DRB CASE ACTION LOG (Site Plan - B. Permit)

DRB Application No.: 09DRB-70268 Project # 1007412
 Project Name: Ujha Linda Subd.
 Agent: John D. Rupley Phone No.: _____

RE: Project #1007412
09EPC-40022 Site Development – Building Permit
Hoffmantown Church, 8888 Harper NE, Albuquerque, NM 87111

FILE: **Project # 1007412**
09EPC-40022 SITE DEVELOPMENT -
BUILDG PRMT

PROJECT NUMBER: 1007412
 Application Number: 092RB-10268

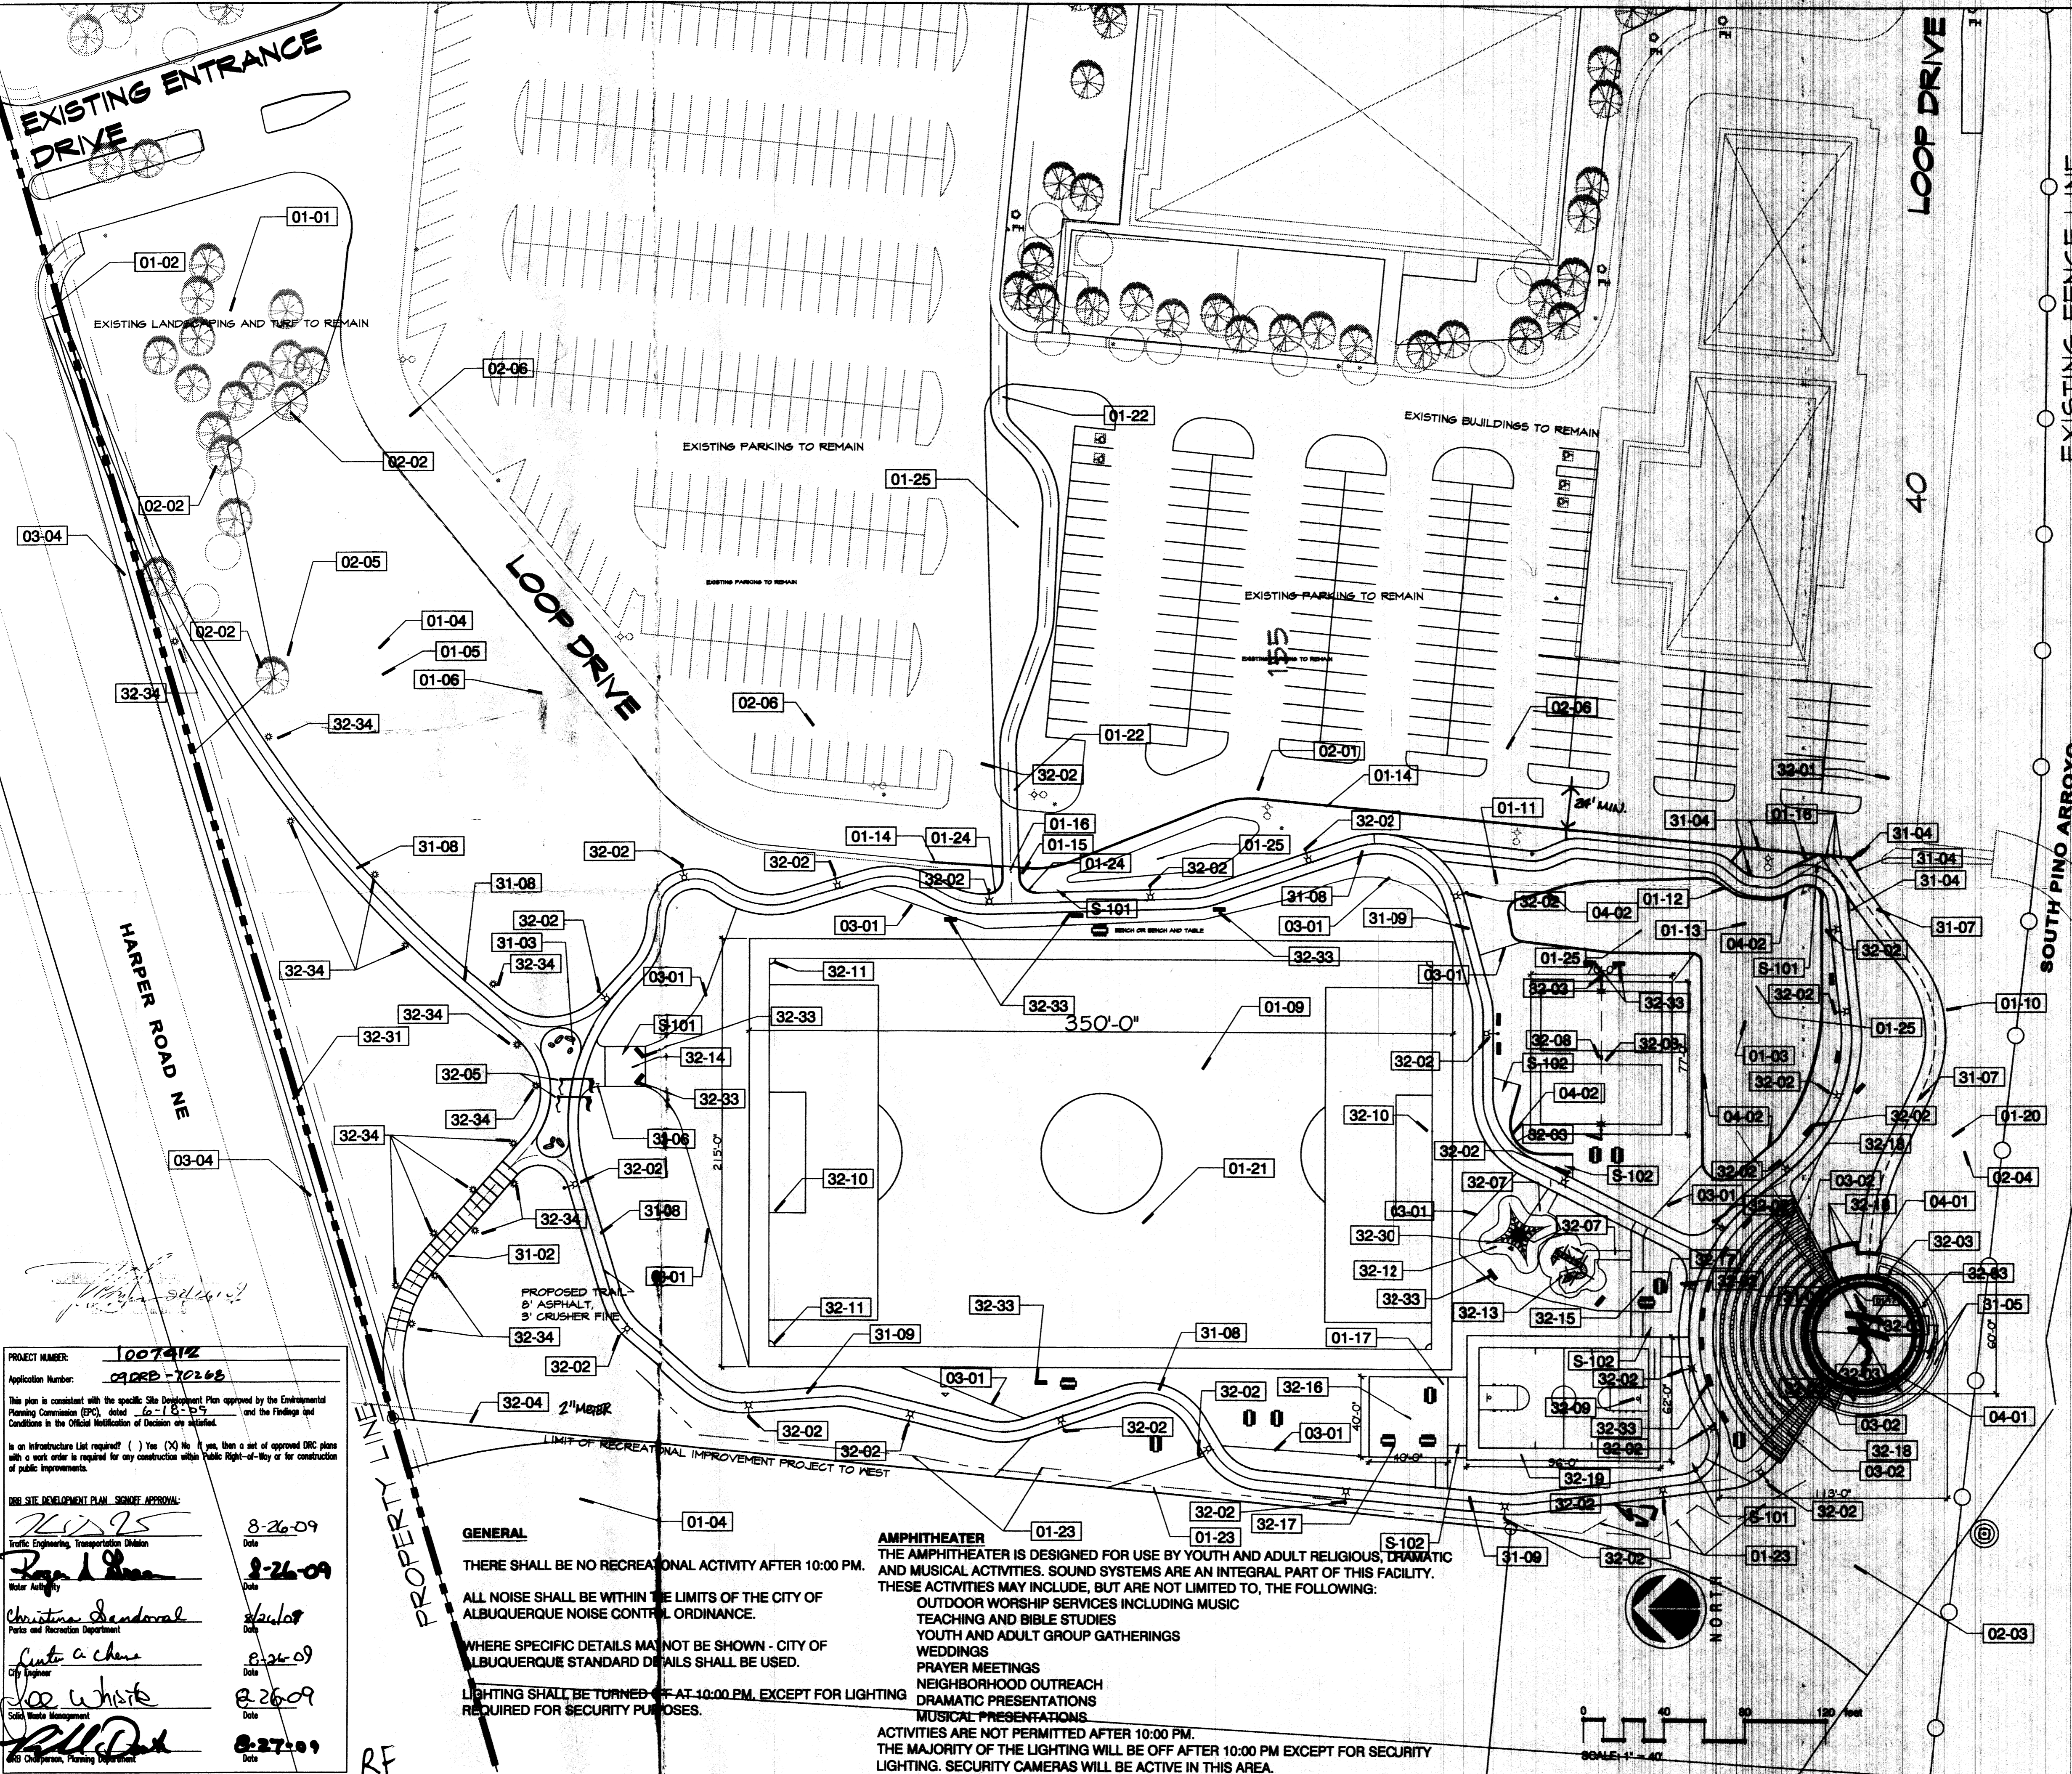
2. Prior to application submittal to the DRB, the applicant shall meet with the staff planner to ensure that all conditions of approval are met.
3. Reference note 01-22 shall show the width of the sidewalk/handicap ramp on the site plan for building permit.

4. Lighting:
 - a. All (11) of the lights with reference note 32-03 shall be 28' tall and be allowed one single banner, with the exception of the three lights on the far north side that are closest to the neighborhood (these lights shall be eliminated).

- b. All light poles will have only one head except for fixtures south of the soccer field.
 - c. All area lighting shall turn off at 10:00 pm, except for pedestrian lighting, which may remain on for security reasons.

- d. The number of security cameras and their locations on the light poles shall be shown on the site development plan for building permit.
 - e. The placement of lighting for Sheet 11 of 13 (LU1.01) shall be consistent with that of Sheet 2 of 13 (LC1.010).

5. Landscaping:
 - a. Proposed Russian Olive trees adjacent to the arroyo will be replaced with Pinon Pine trees.
 - b. The root collar on the planting detail shall be at finish grade.

- d. The landscaping plan shall show the installed size of all plants as well as the mature size of all plants.

- a. All noise shall be within the limits of the City of Albuquerque Noise Control Ordinance.
- b. The uses for the amphitheater shall be clearly indicated on the site development plan for building permit.

7. There shall be no recreational activity after 10:00 pm.

8. The proposed amphitheater seating will not be expanded beyond 325 seats.

3. The width of sidewalk in Reference Note 01-22 has been modified to show 8 foot width. See sheet LC101/02 of 13.
4. Lighting issues:
 - a. The fixtures on the trail are fixture 32-02 (the 32-02 and 32-03 are 28' tall fixtures – all equipped to support security cameras) there have been and are 32 light standards of this type. The 32-03 fixtures are primarily at the volleyball court and amphitheater, and 16 low bollard lights at the stepped walk and trail near Harper.

- i. The three duplicated fixtures on the north side of the property have been removed.
 - b. A note has been added to the light pole detail on sheet 01 of 13 stating that only those fixtures south of the playfield may have double heads.

- c. Notes have been added on sheet 02 of 13.
 - d. The number of security cameras is still an issue with the equipment to be used. **ALL LIGHT POLES ARE CAPABLE OF HAVING SECURITY CAMERAS.** It is currently estimated that 7 to 9 cameras will be located on the western portion of the site.

- e. Sheet 11 of 13 now is in agreement with all sheets, using the same base sheet for light fixtures.
5. Landscaping:
 - a. Russian Olive Trees adjacent to the arroyo on the south have been replaced with Pinon Pine as noted on sheet LP105, 05 of 13.

- b. The root collar on the planting detail has been modified to form a flush at grade condition, see sheet LD506, sheet 07 of 13, detail number 6.
 - c. A note has been added to sheet LP102, sheet 03 of 13 incorporating the note required by the Urban Forester.

- d. The planting plan graphics show the mature size of the plant materials (all sheets), the installed size in indicated in the planting schedule LP101 sheet 06 of 13, AND that schedule is modified to show both installed and mature height of major plant materials.

6. Noise:
 - a. A general note has been added to LC101 sheet 02 of 13 showing compliance with the City of Albuquerque Noise Control Ordinance.
 - b. A detailed listing has been added to LC101 sheet 02 of 13 (Site Development Plan for Building Permit) to enumerate anticipated uses of the Amphitheater.

7. Recreation Activity has been limited not to occur after 10:00 PM. This note has been added to LC101 sheet 02 of 13 (Site Development Plan for Building Permit)

8. A note has been added to sheet 12 of 13, LC105 (sheets which describe the amphitheater) that it will not be expanded beyond its original designed seating capacity, estimated at 325 seats.
9. Public Service Company comments will be followed and all easements have been acknowledged.
10. City Engineer and NMDOT –
 - a. Improvements are being made to the sidewalk along Harper Road for this portion of the work and will comply with City of Albuquerque Standards while allowing the continued running track of this large tract of land used daily by the public.
 - b. No previous requirements are outstanding.
 - c. It is the intent of the Design Firm and the owner to fully comply with the DPM Standards.
